**Consultation Response from KC,  
Highways Development Management****2025/93084 14, Thornhill Park Avenue, Thornhill, Dewsbury, WF12 0DA****Erection of detached dwelling****Date Responded: 15/01/2026****Responding Officer: D. Stainsby****Responding Ref: K16-19NE/2****RECOMMENDATION.**

This application seeks approval to the erection of one dwelling and demolition of an existing dwelling at 14, Thornhill Park Avenue, Thornhill, Dewsbury.

DATE: 28.11.25 DRAWN: AHD
SCALE: 1:50,100, 1250 CHECKED: ANK
SIZE: A1 DRG NO: 25.2796.02C

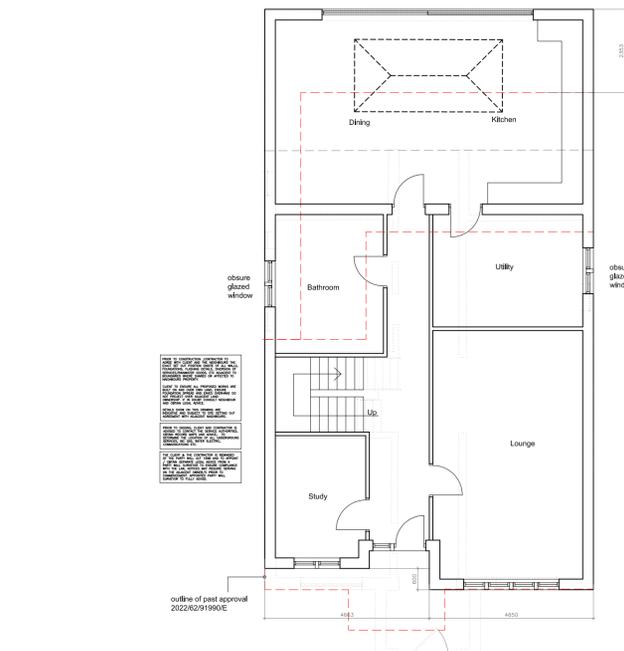
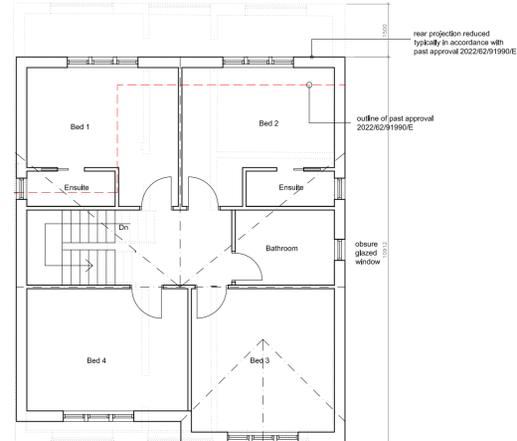
The application site is located at the end of a cul-de-sac and the proposals show 4 off-street parking spaces to be provided within a driveway forecourt to the front of the property.

Given that this is a replacement dwelling and sufficient off-street parking is shown to be retained Highways Development Management have no objection to these proposals.

The approved vehicle parking areas will need to be surfaced and drained in accordance with the Communities and Local Government; and Environment Agencies 'Guidance on the permeable surfacing of front gardens (parking areas)' published 13th May 2009 (ISBN 9781409804864) as amended or superseded.
